Letter No. **B2/6550/2000**

**Area Plans Unit - Planning Permission -  
Proposed construction of Ground Floor + 3 Floor  
Departmental store-cum-residential building with  
7 dwelling unit at R.S.No.1127/35 & 1133/8,  
Block No.24 of Mylapore village in Door No.89,  
Avvaishanmugam Salai, Royapettah, Chennai-14 -  
Development Charge Advice - sent - Regarding.**

Ref: **PPA received in SBC No.214/2000,  
on 08.03.2000.**

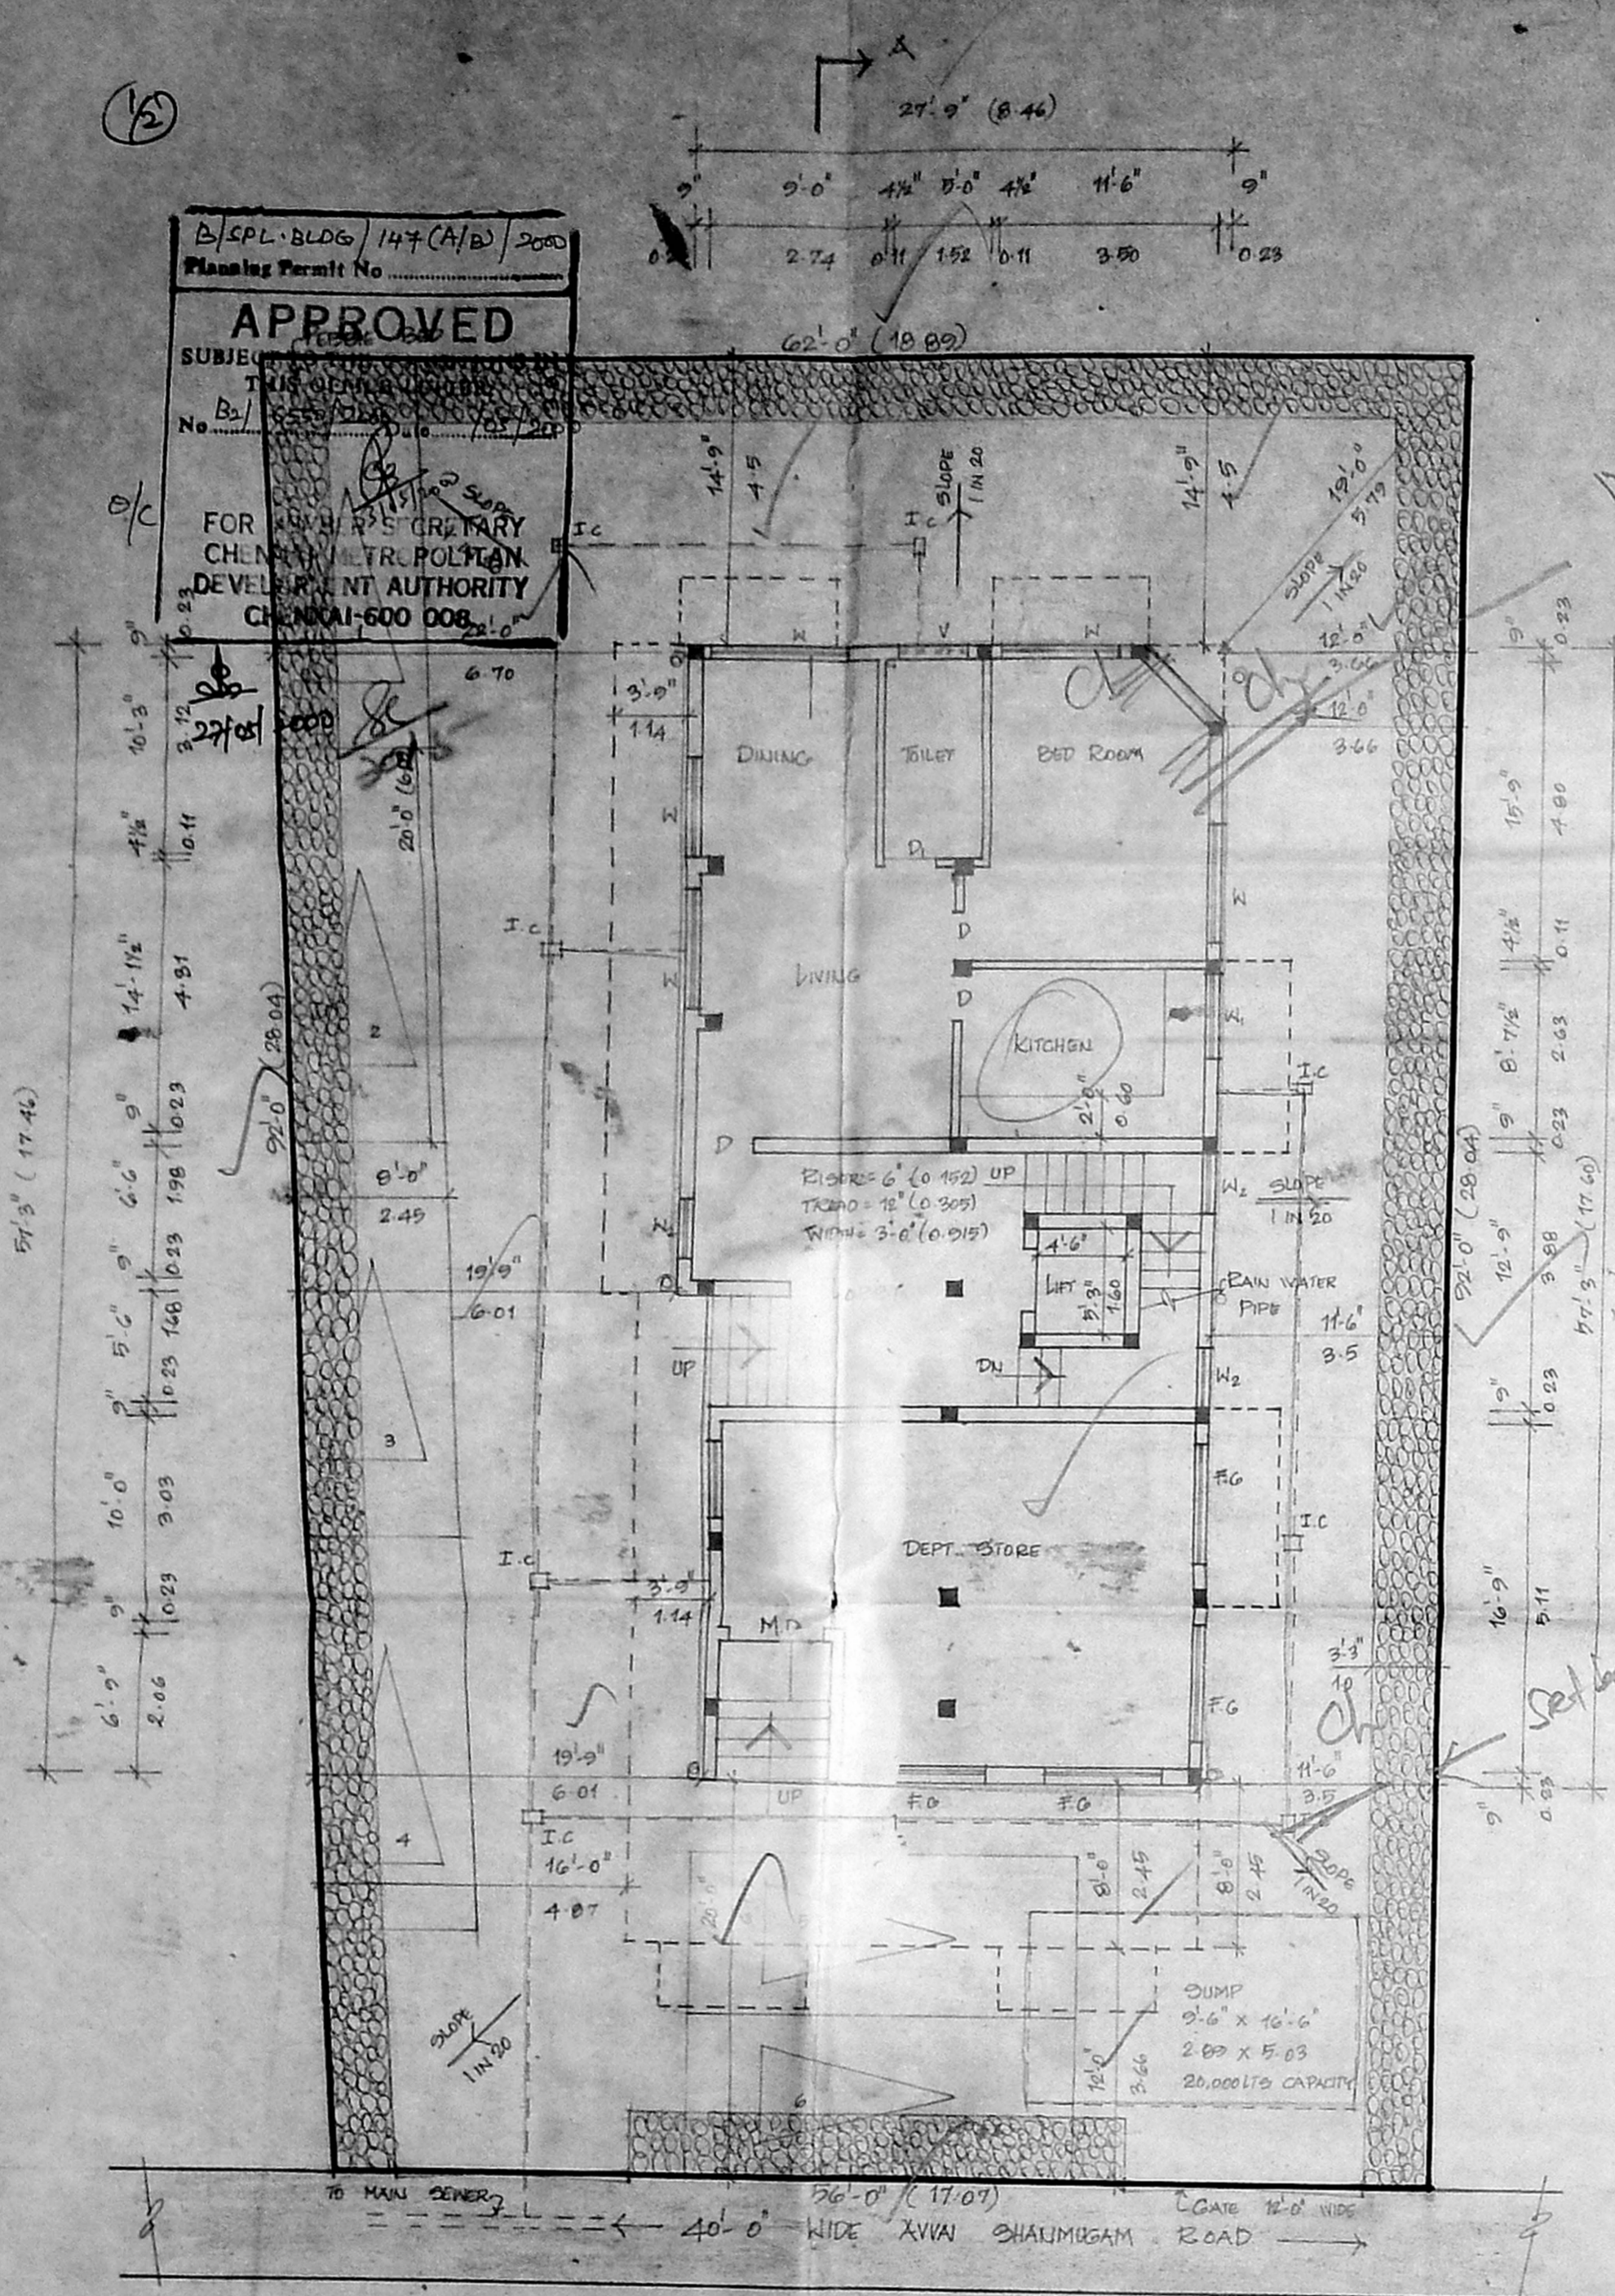
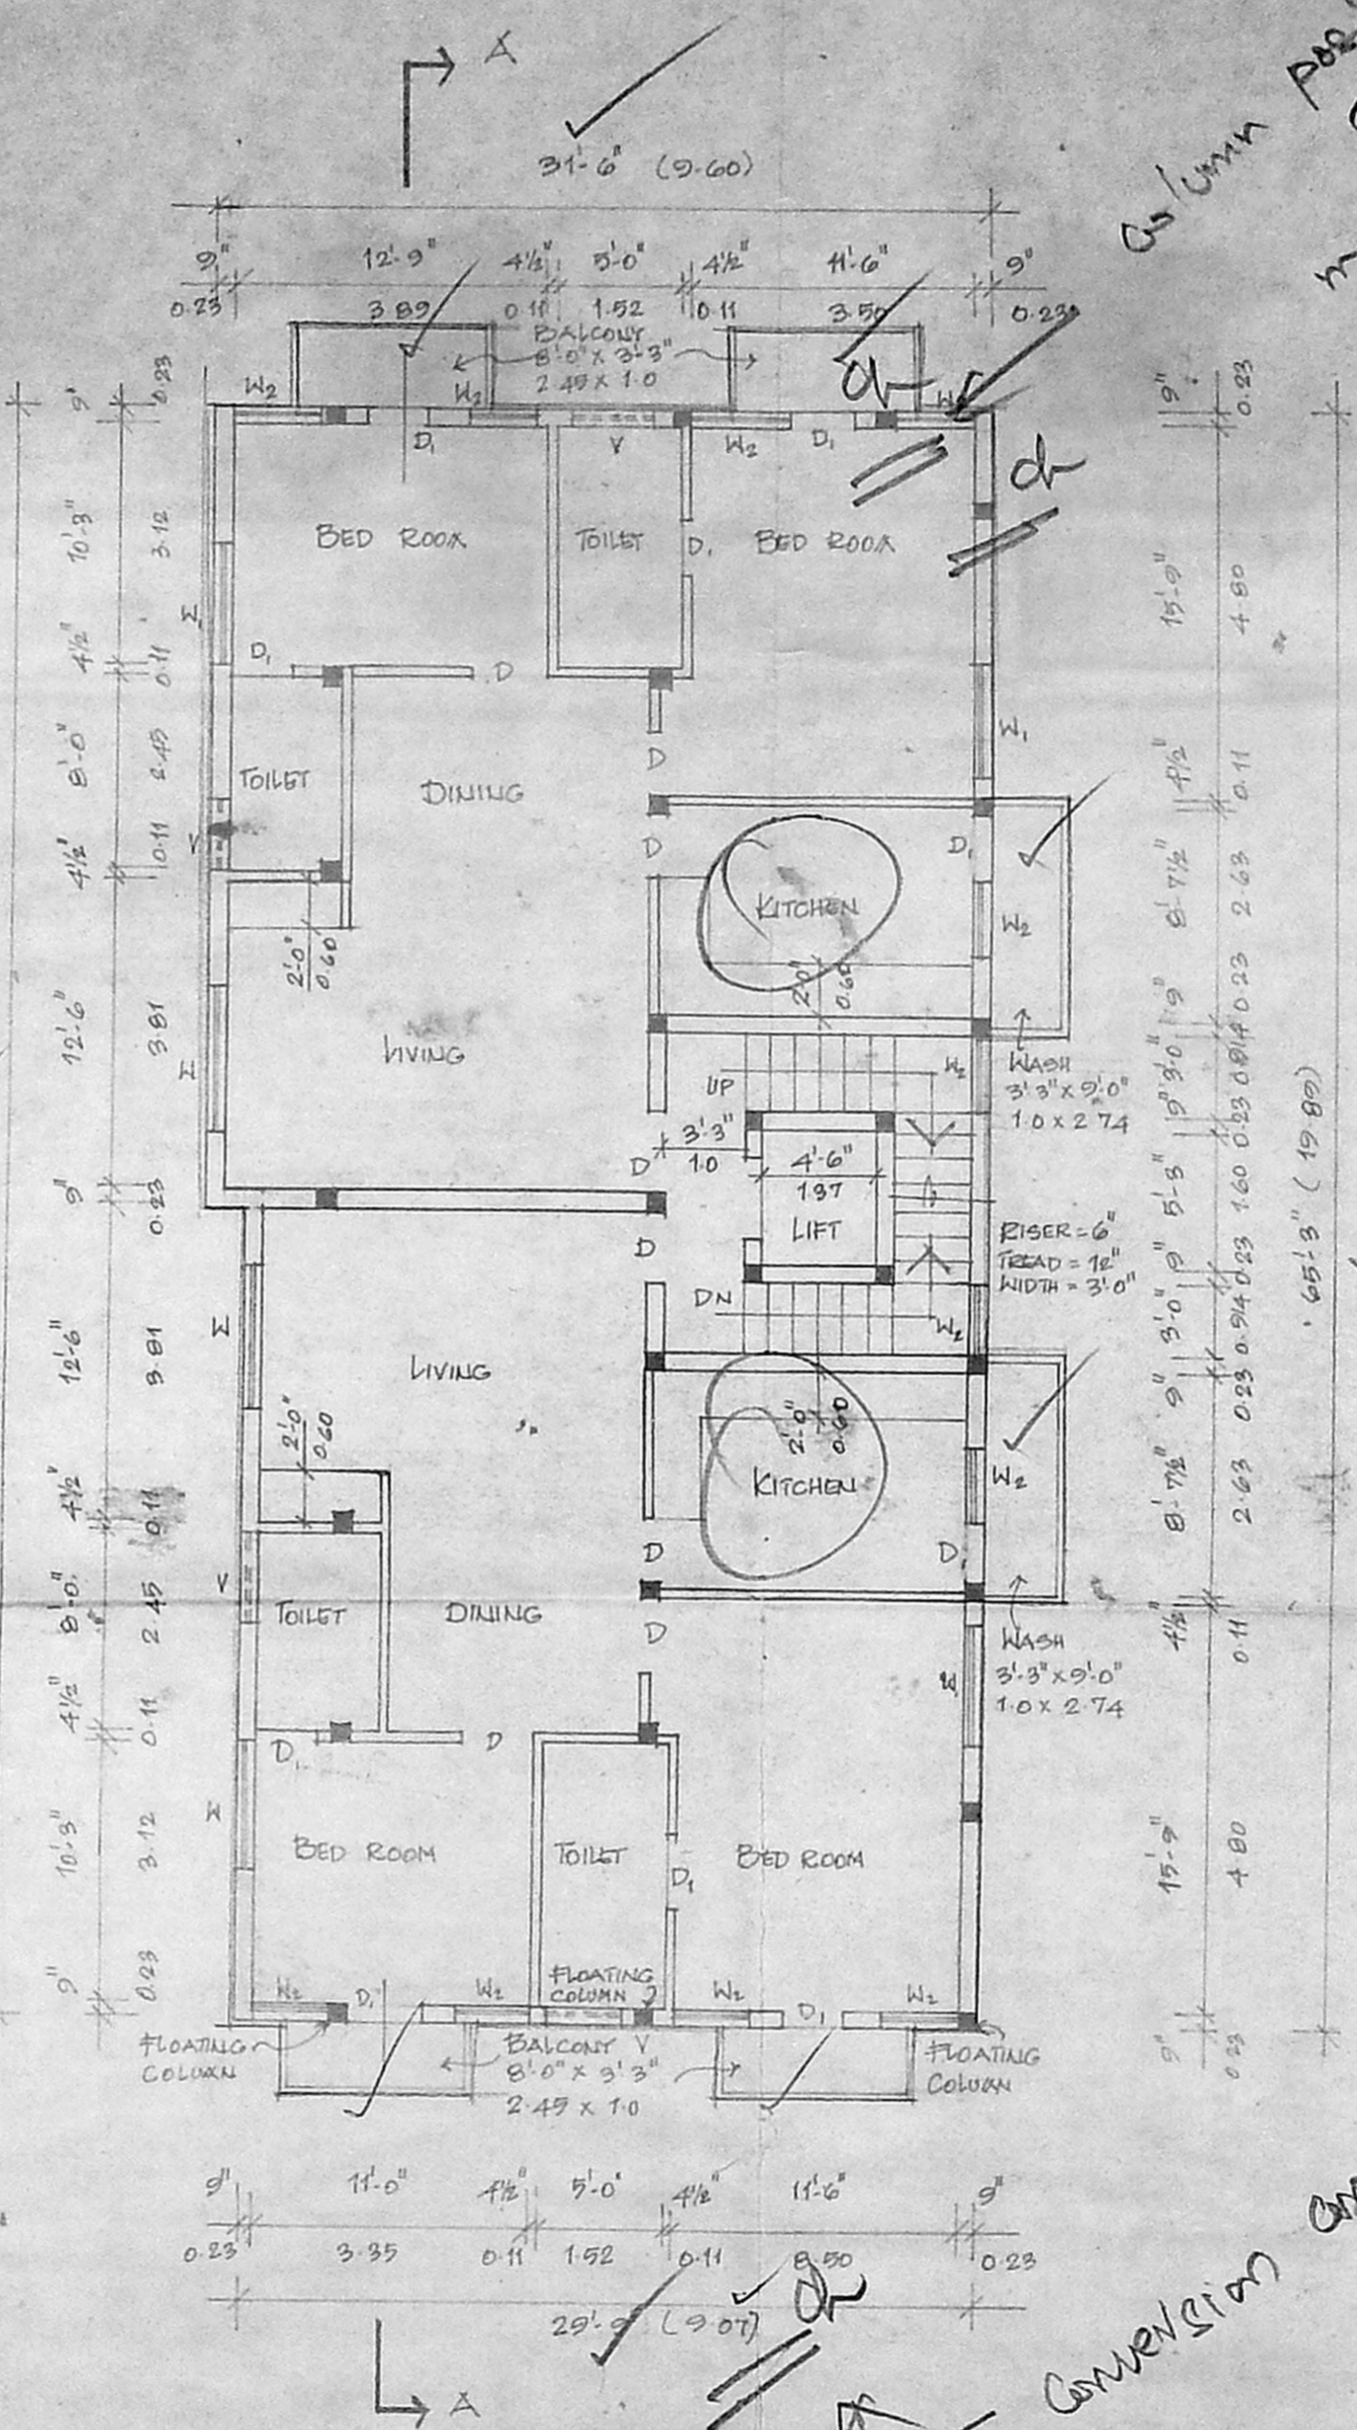
- 1) Revised plan rectifying the following defects:**
  - a) Turning radius satisfying Development Control Rules.
  - b) Mention the set back space measurement at all the crucial point.
  - c) Correcting the conversion measurements from feet to Metre in the typical floor plan.
- ii) Copy of OCM sanctioned plan duly attested by the officials of Corporation of Chennai.**
- iii) Copy of ownership documents, PLR extract and other particulars duly attested by a Notary Public.**
